RFI #: 198
Date: 10/19/2012
Job: EB-02 Keller Springs Lofts
Phone: 877-777-5115

Subject: 8 x 8 post's Substitution request

RFI #: 206
Date: 11/13/2012
Job: EB-02 Keller Springs Lofts
Phone: 877-777-5115

Subject: B2 part 4 pier cap at south side of patio

SHEET NUMBER
S2.14P

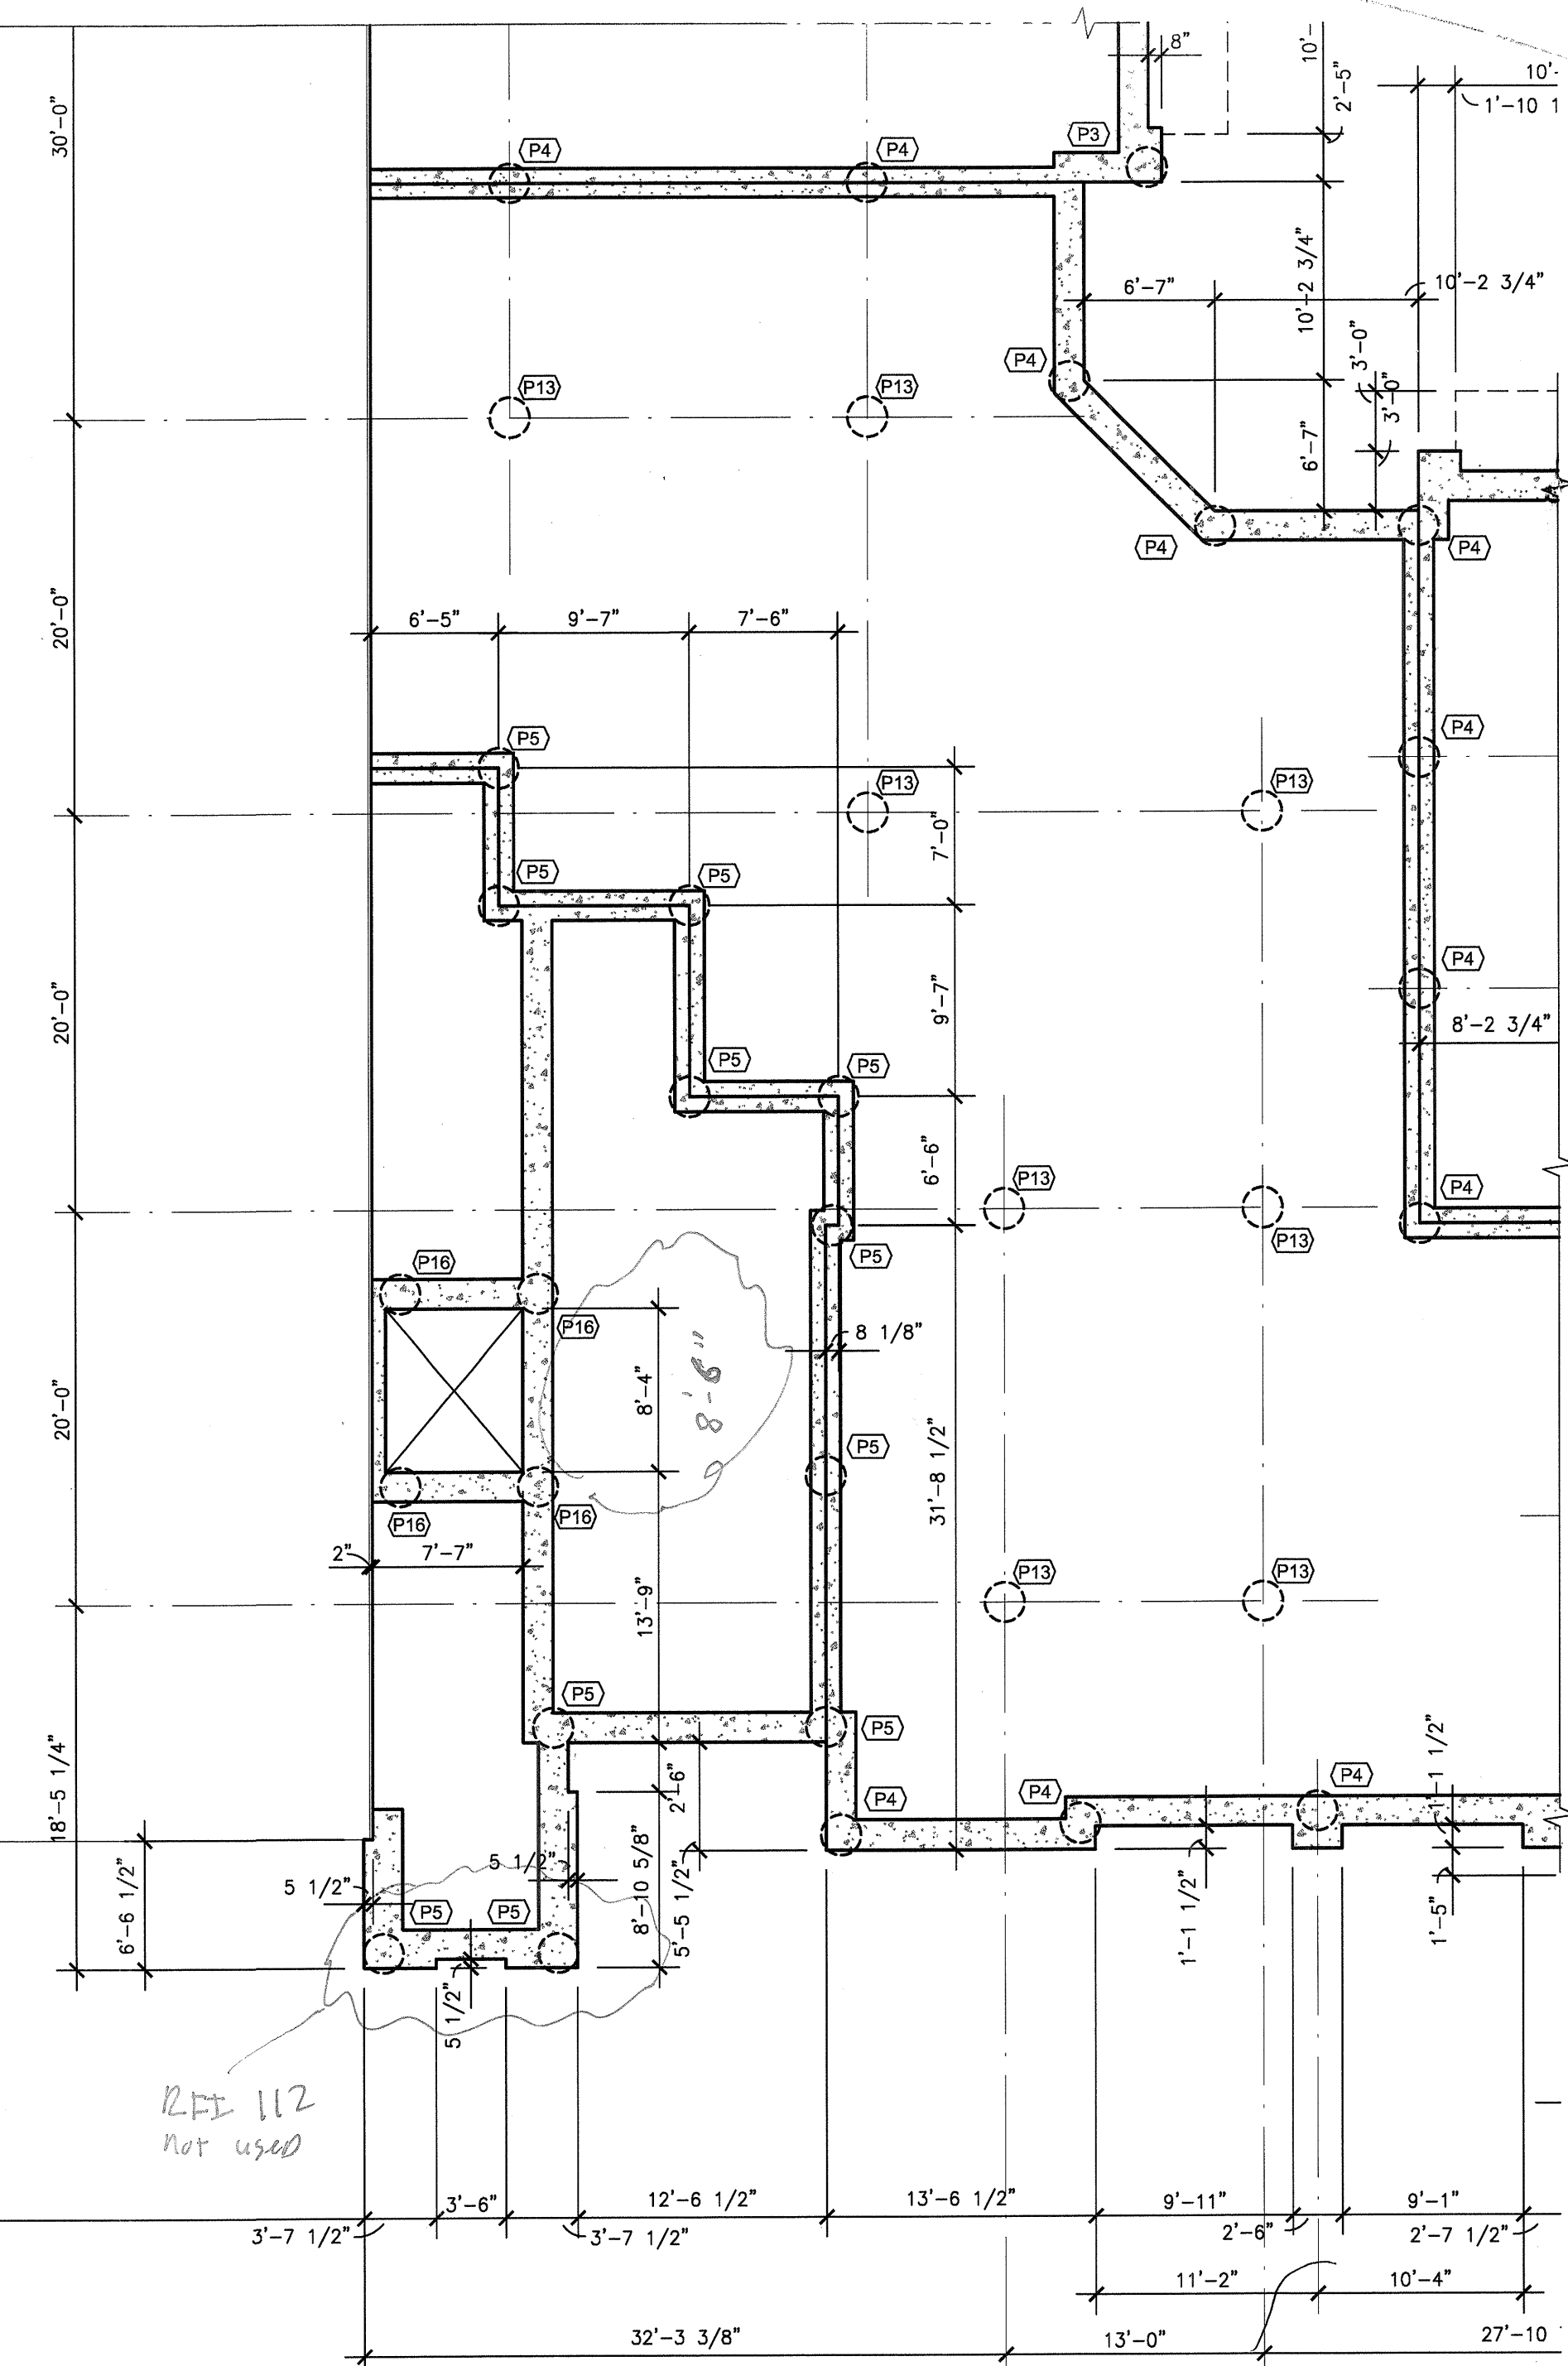
Request: **Date Required: 11/20/2012**
At the B2 part 4 patio pier cap we raised the south side of the patio for positive drainage. By doing this, the poured pier cap became recessed below the finished patio slab by about 5". We need a fix to rise the top of the pier cap out of the elements for the column post to sit on.

Response:
Per our conversation yesterday afternoon, please drill and epoxy grout in four #4x0'-8" dowels (with one #3 tie) into the existing pier cap and cast a new 6" tall cap extension.
